Parramatta Regional Branch  
National Trust of Australia (NSW)  
nat.trust.parramatta@hotmail.com

5 October 2011

On behalf of the Parramatta Regional Branch of the National Trust of Australia (New South Wales), I wish to make a submission on the proposed Mixed Use Development located at 330 Church Street, Parramatta.

02 LONG SECTION LOOKING NORTH
1:200 @A1

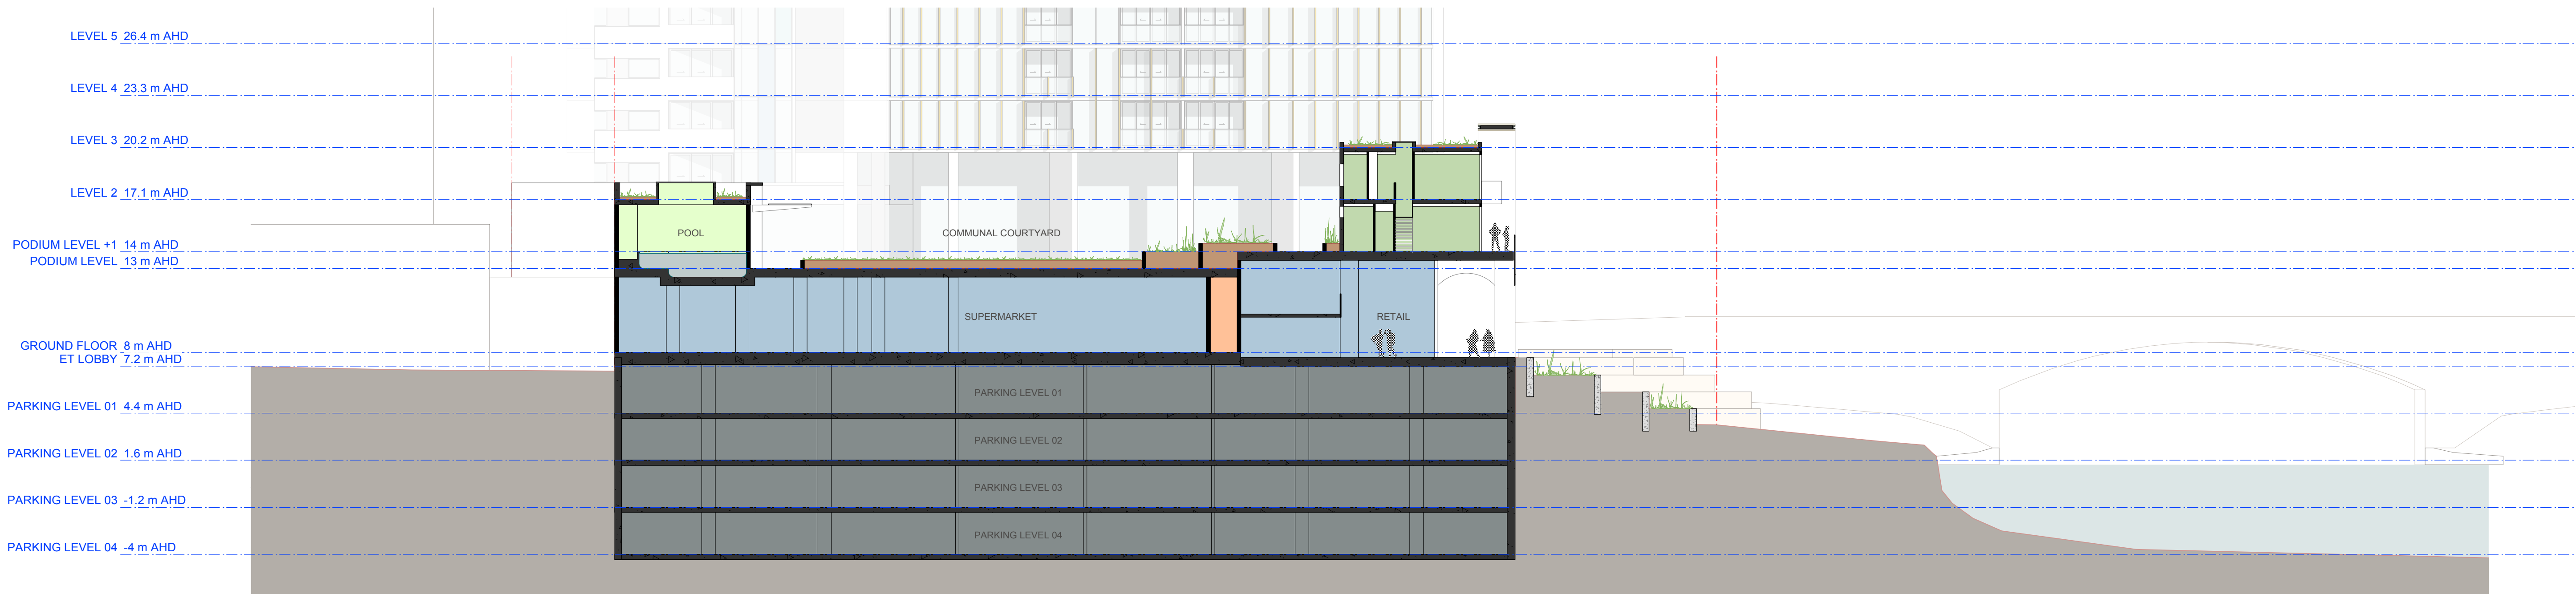
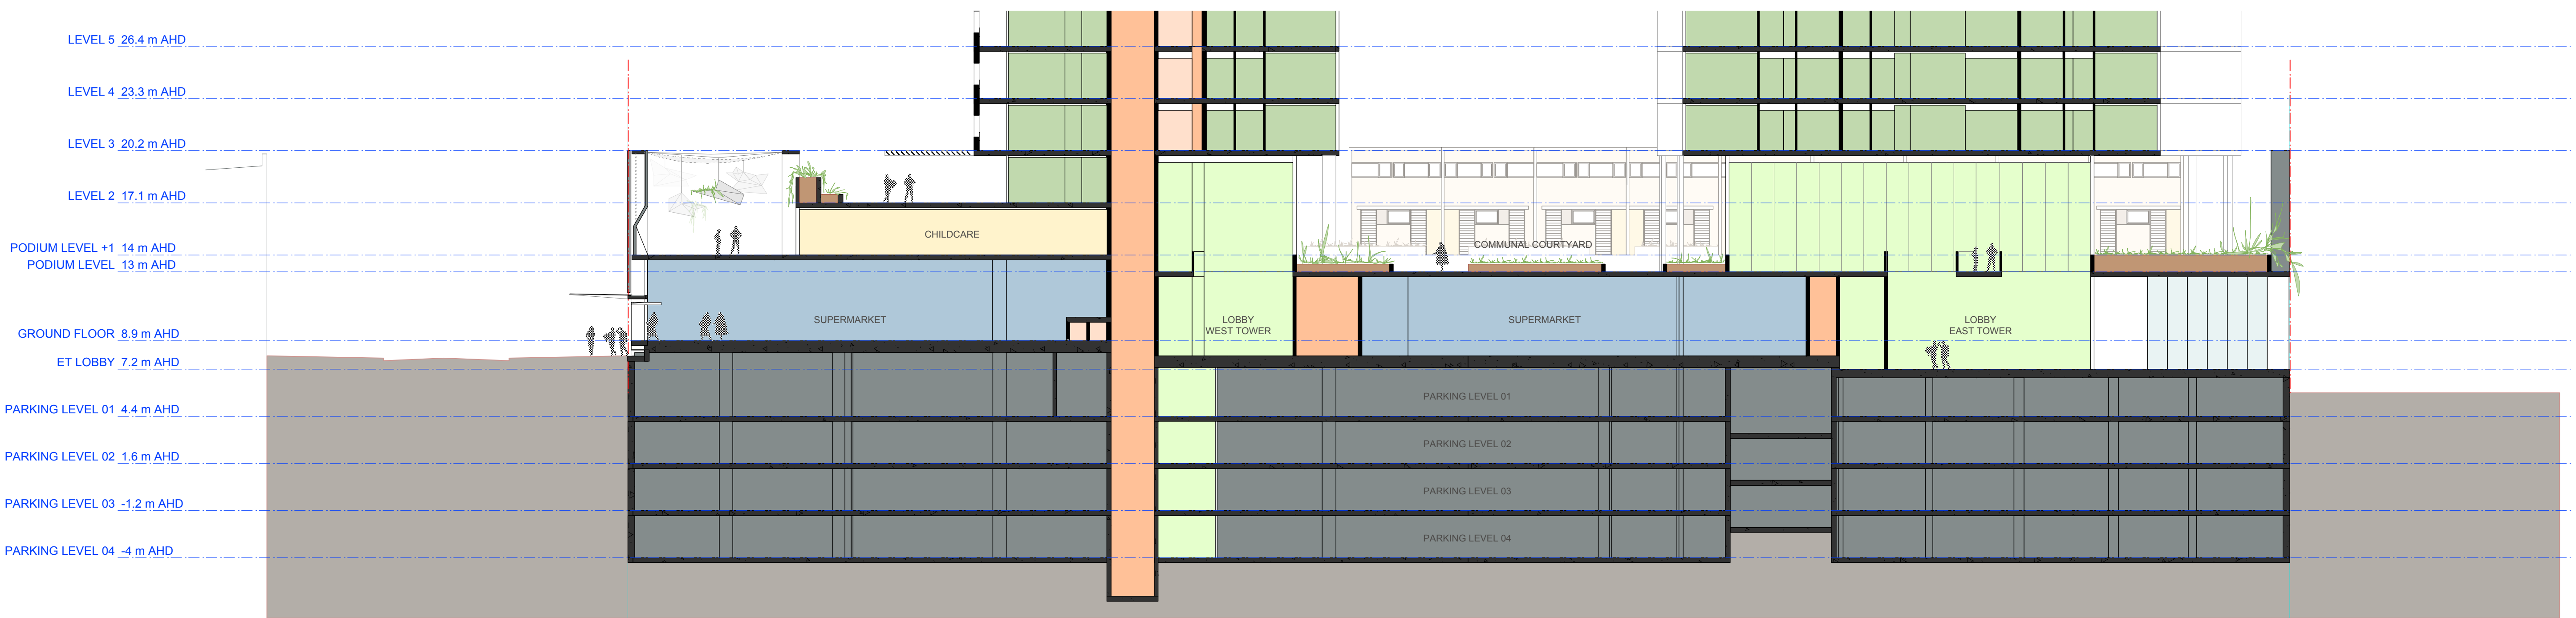
Of greater significance however is the potential impact on the Parramatta Regional Park itself an identified heritage item of State significance. Even though located some distance from the site, the height of the proposed towers will intrude into the skyline when viewed from many locations in the park. The visual impact will be more obvious from Old Government House and Domain, a UNESCO World Heritage Site.

It is our opinion that the Statement of Heritage Impact is inadequate as it does not adequately address the extent to which the development will affect the heritage significance of heritage items in the vicinity of the site including Parramatta Regional Park and particularly Old Government House and Domain. The visual impact will be exacerbated by the breaches in the height requirements in LEP 2007.
